Response to Submissions Letter - Traffic/Vehicle Movements

DATE: 5 December 2016

RE: Proposed Resource Recovery Facility, 20 Hearne Street Mortdale (SSD 7421)
Response to Submissions

Traffic Control Plan

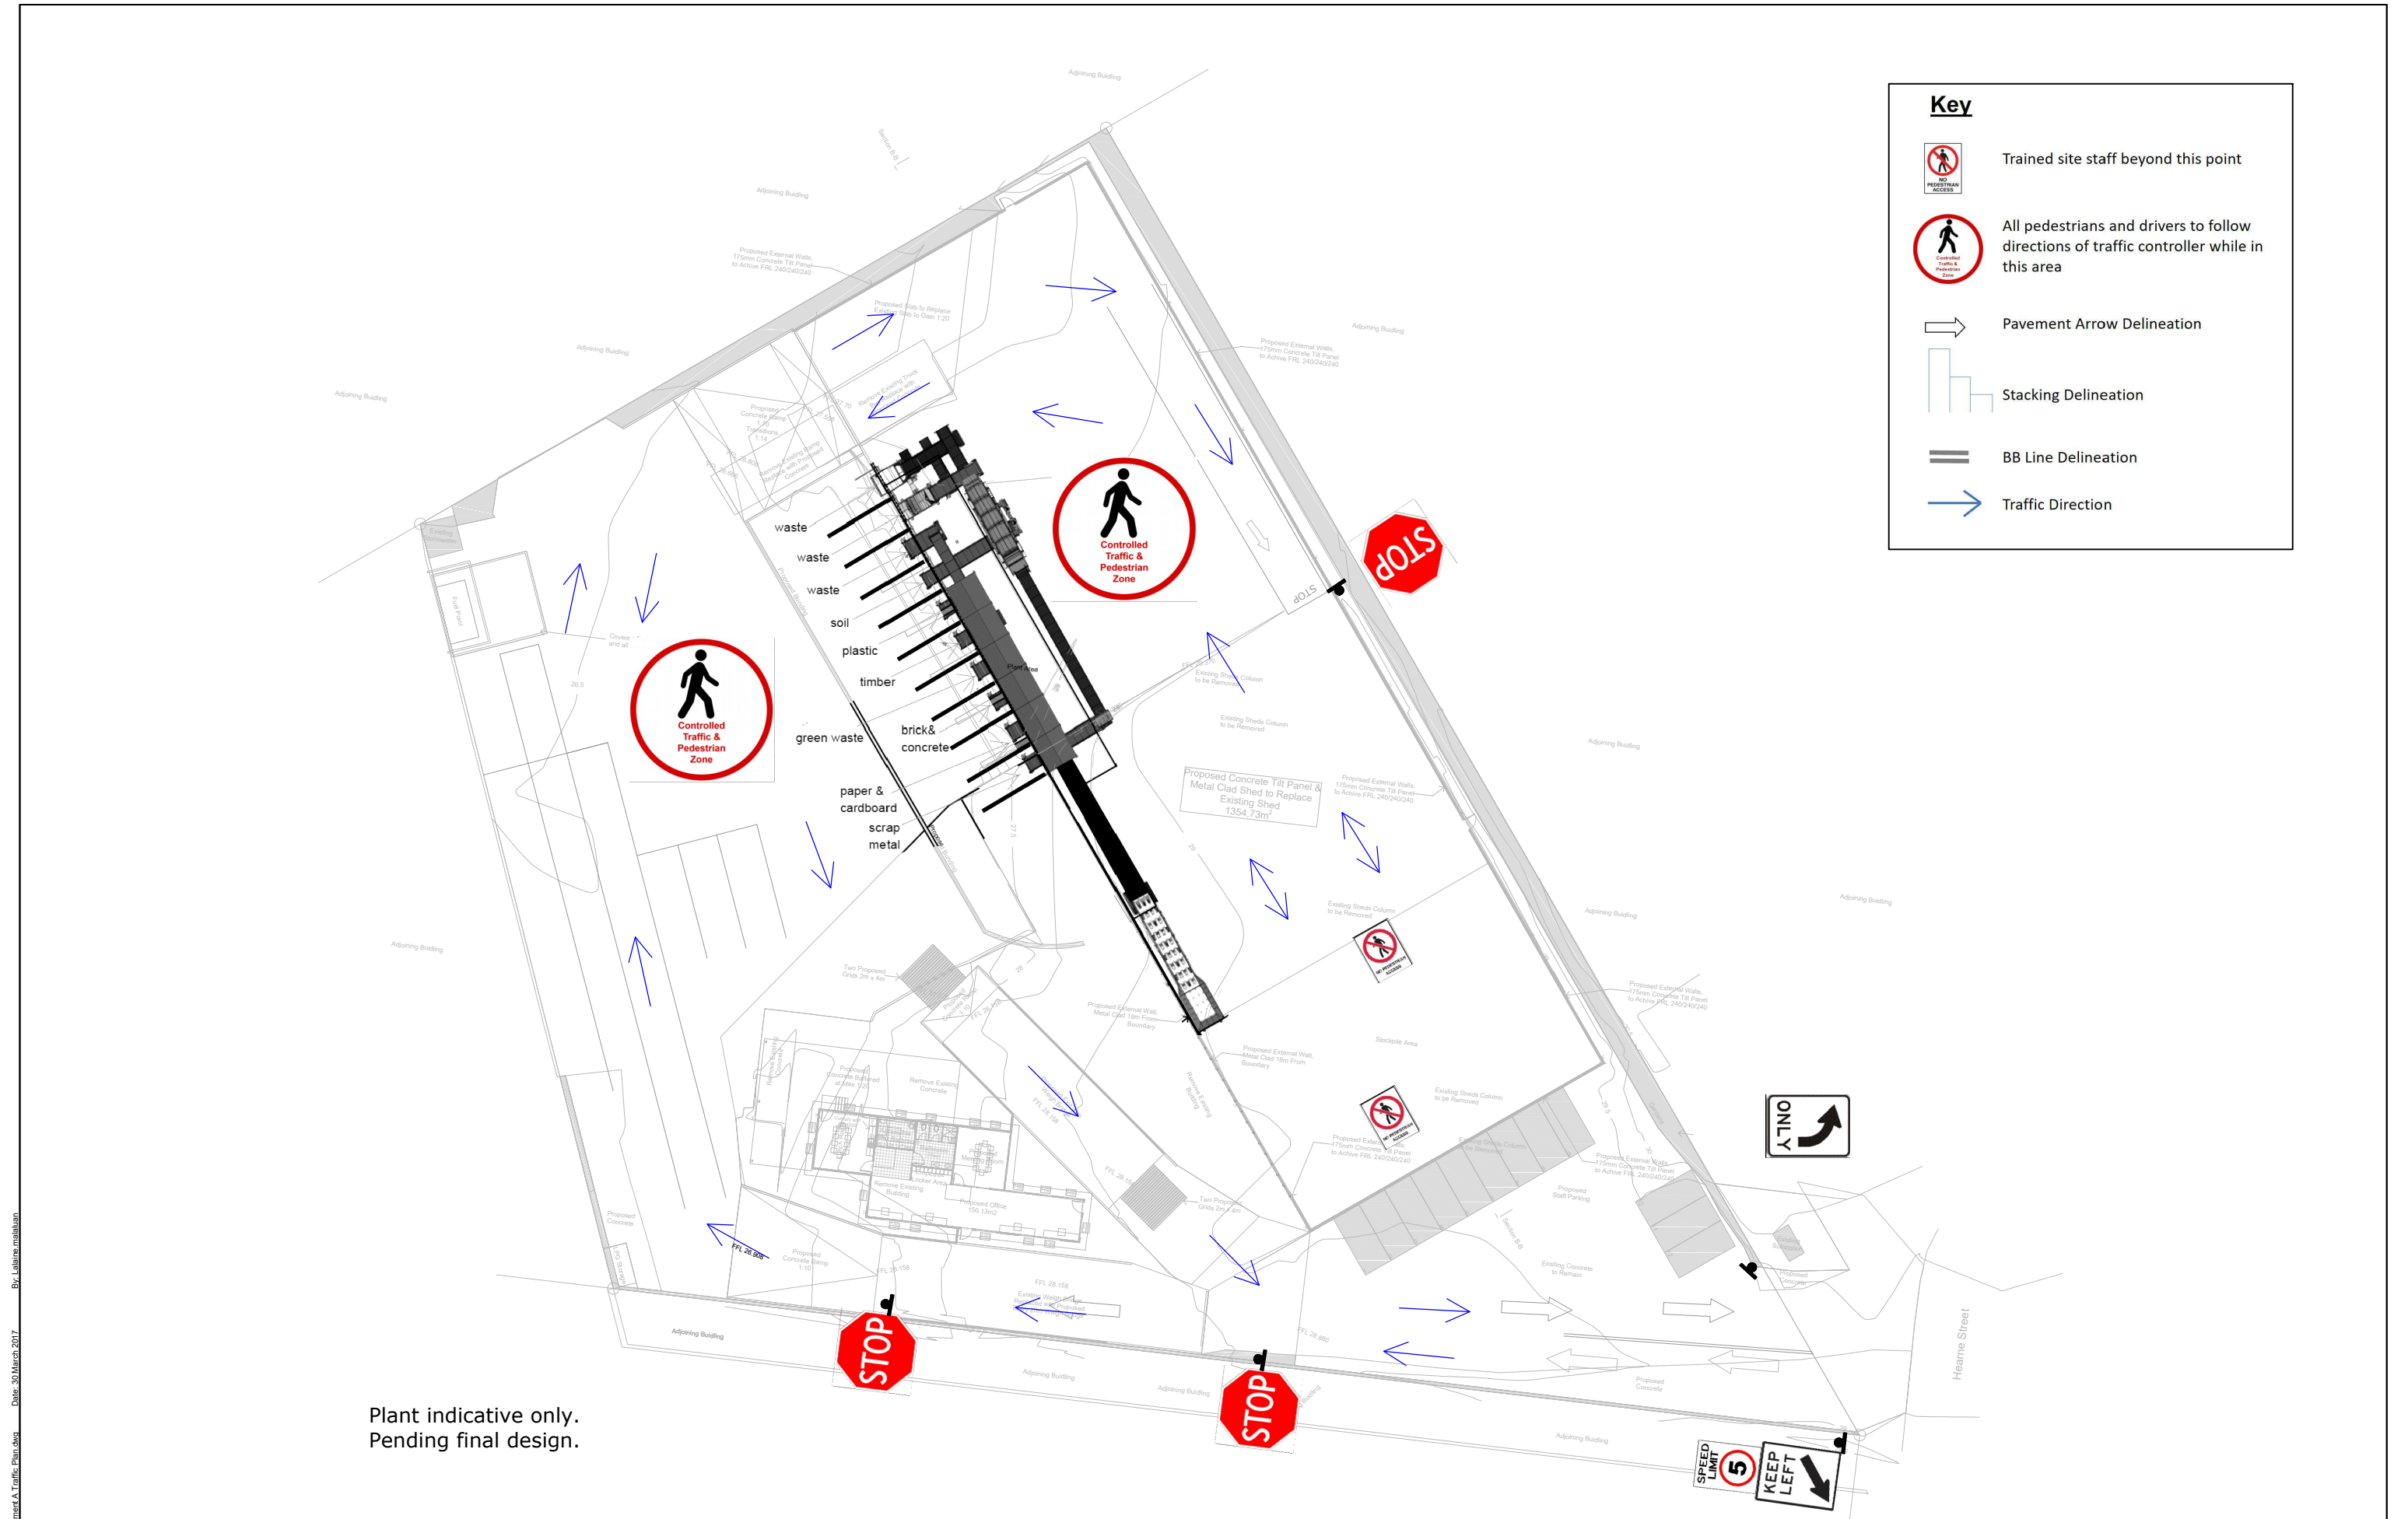
Provide a plan showing the potential stacking of vehicles within the site, including proposed traffic controls to be implemented to avoid queuing within Hearne Street.

TTPP has prepared plans showing the heavy vehicle stacking arrangement and traffic controls onsite. The stacking plan demonstrates adequate queuing space for trucks within the boundary of the site while the traffic control plan indicates the general location of signage to regulate safe movement throughout the site.

Driveway Access Vehicle Swept Paths

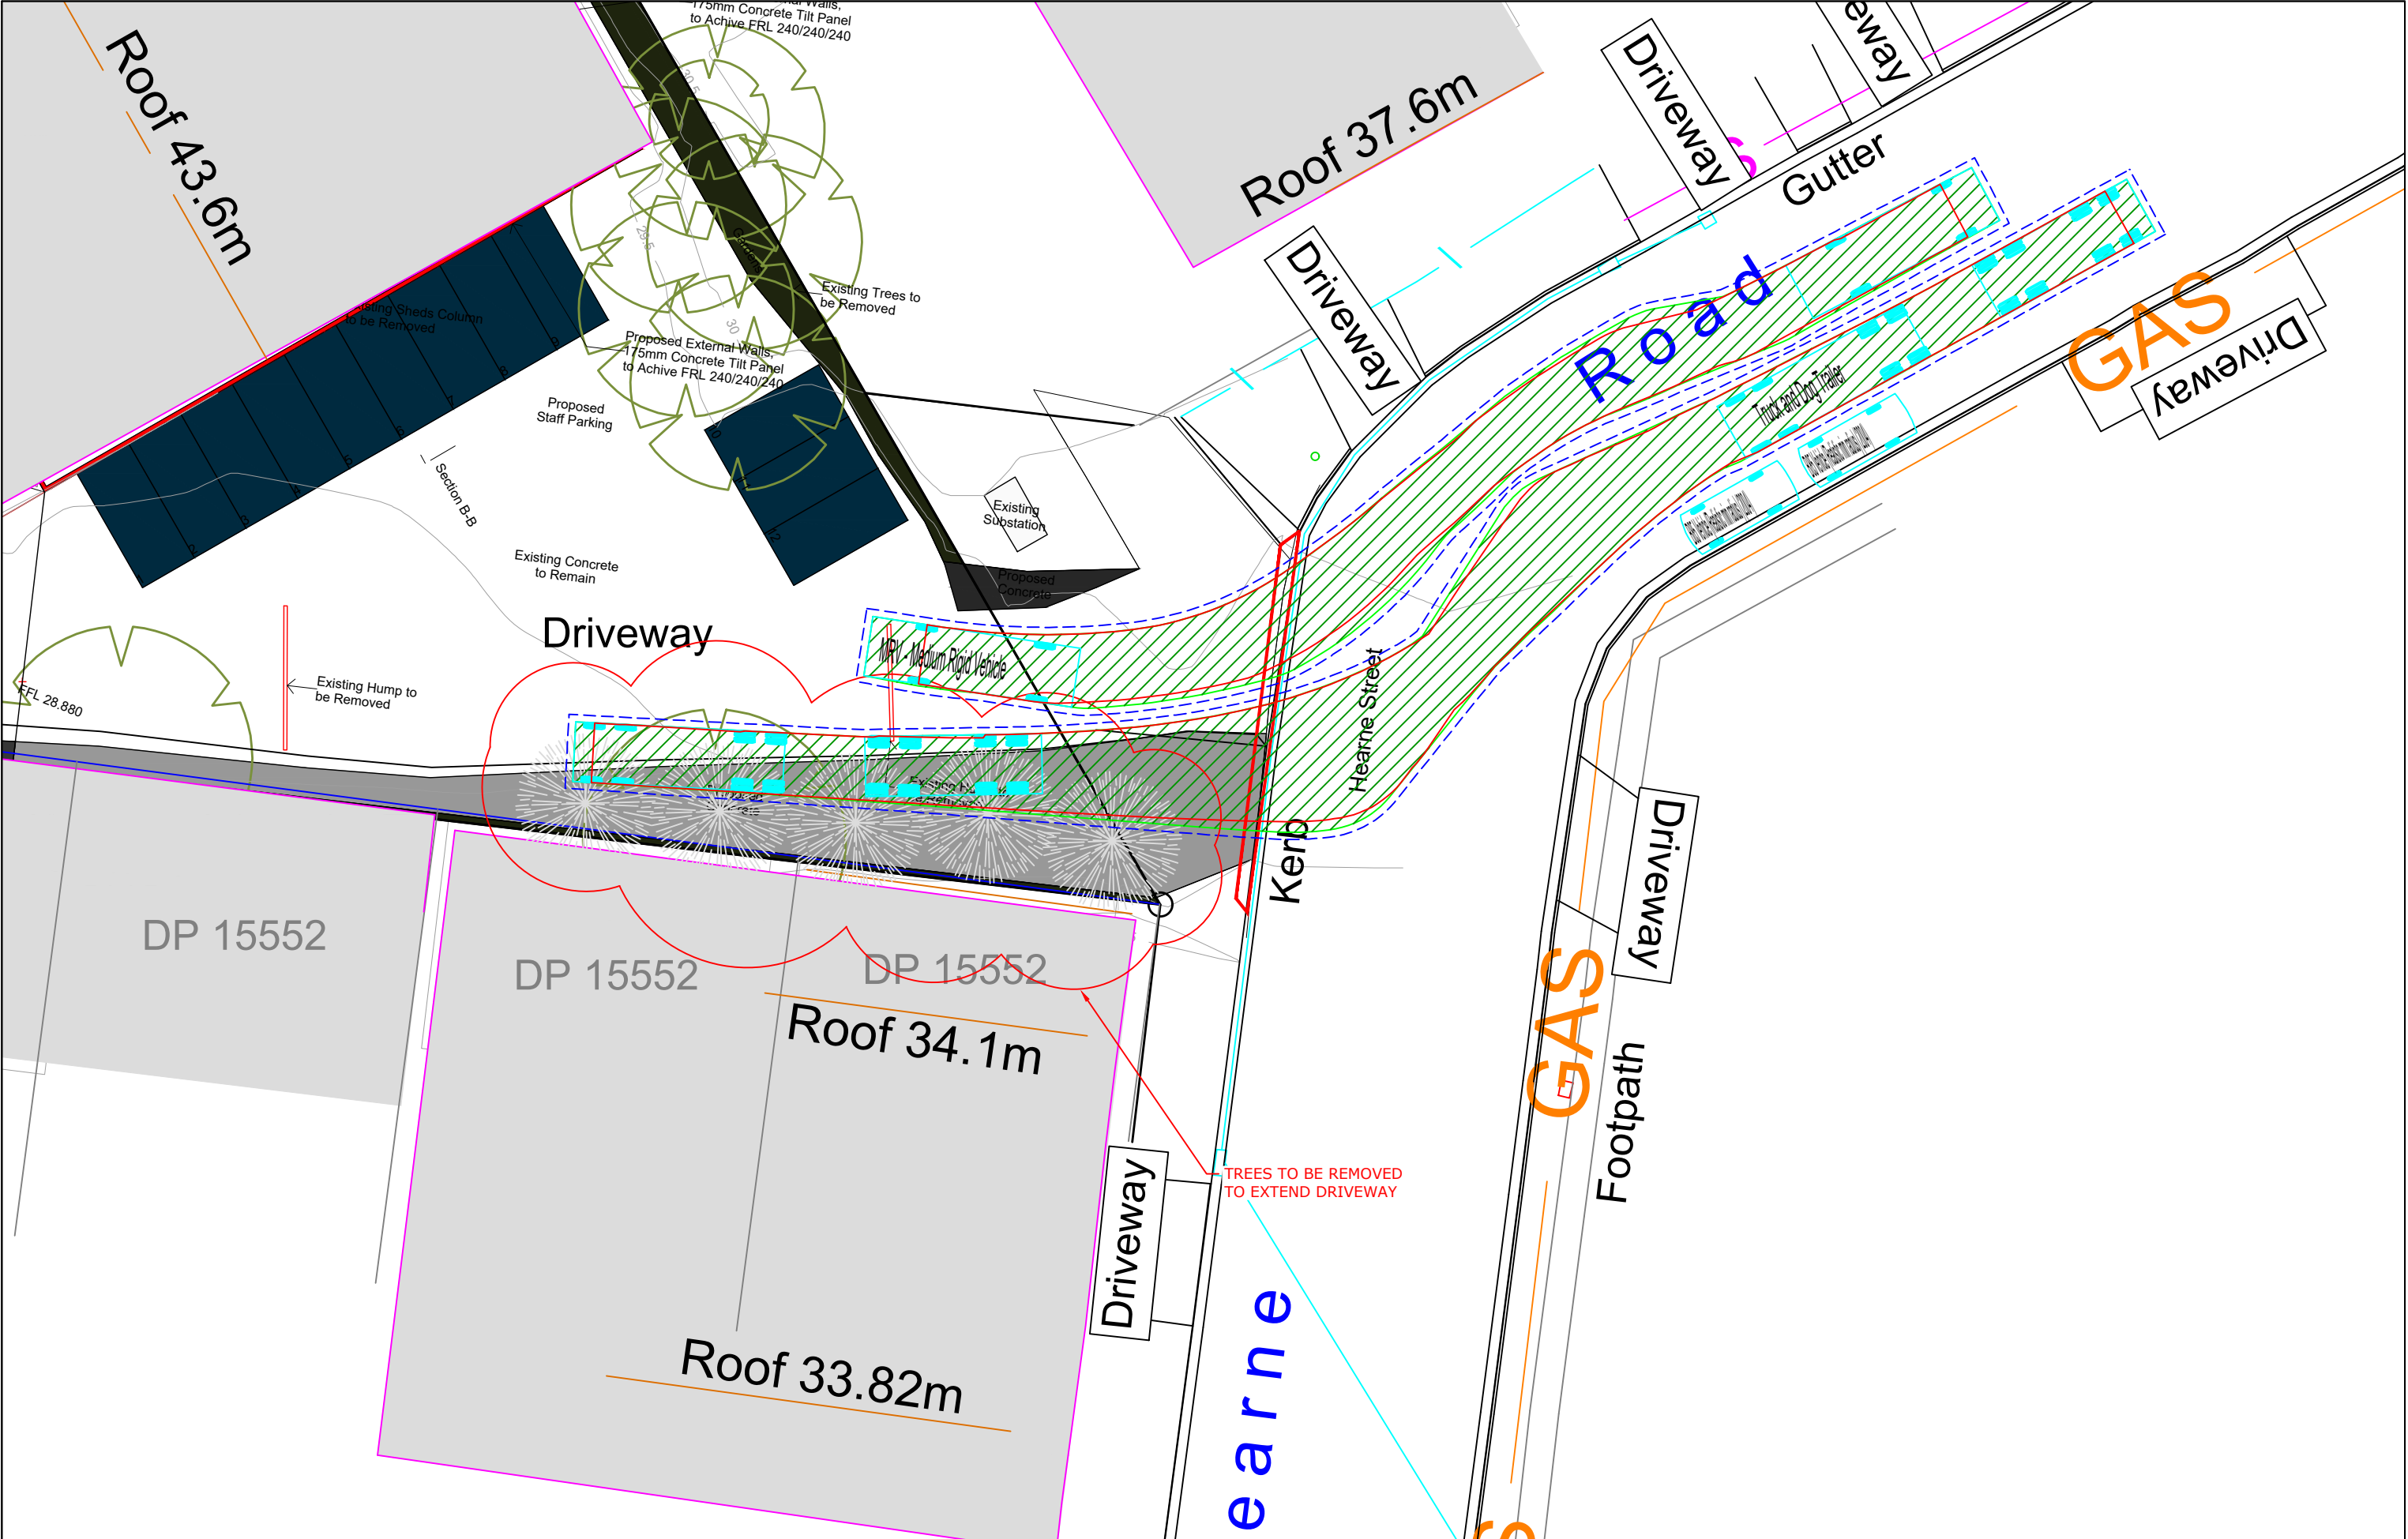
Provide a detailed design of the proposed accessway having regard to the swept path of the largest vehicles entering and exiting the site and potential conflicts resulting from the vehicle movements.

TTPP has undertaken an analysis of the vehicle swept path for trucks accessing the site via Hearne Street on the northern approach. As part of the proposal, the site access driveway is to be widened from 7.4m to 16.2m. The proposed design is confirmed by the detailed survey undertaken by Spatial Technologies (dated 23/09/2016) for the site access and road fronting the site. The driveway widening will involve the removal of five trees and concrete pavement of the pre-existing garden on the south side of the site entrance.

The analysis indicates that inbound and outbound movements undertaken by MRVs can occur concurrently (Figure 1 in Attachment E). Two-way movements by an MRV with a semi-trailer or truck-and-dog can also occur concurrently (Figure 2 to Figure 5 in Attachment E). Two-way movements by larger trucks cannot occur simultaneously. However, it is highly unlikely that two larger-sized vehicles would be undertaking these manoeuvres at the same time. The likelihood of this scenario occurring is further reduced through Bingo's scheduling capabilities, which would prevent two larger vehicles accessing the site simultaneously.

In the rare occurrence of two large vehicles needing to use the accessway at the same time, the vehicle on approach to the site would be required to stand clear around 30m of the site driveway to allow for the exiting vehicle to leave the site. Given the low-speed road environment on Hearne Street driver visibility to large trucks exiting the site would be sufficient for oncoming vehicles to allow a 30m gap ahead.
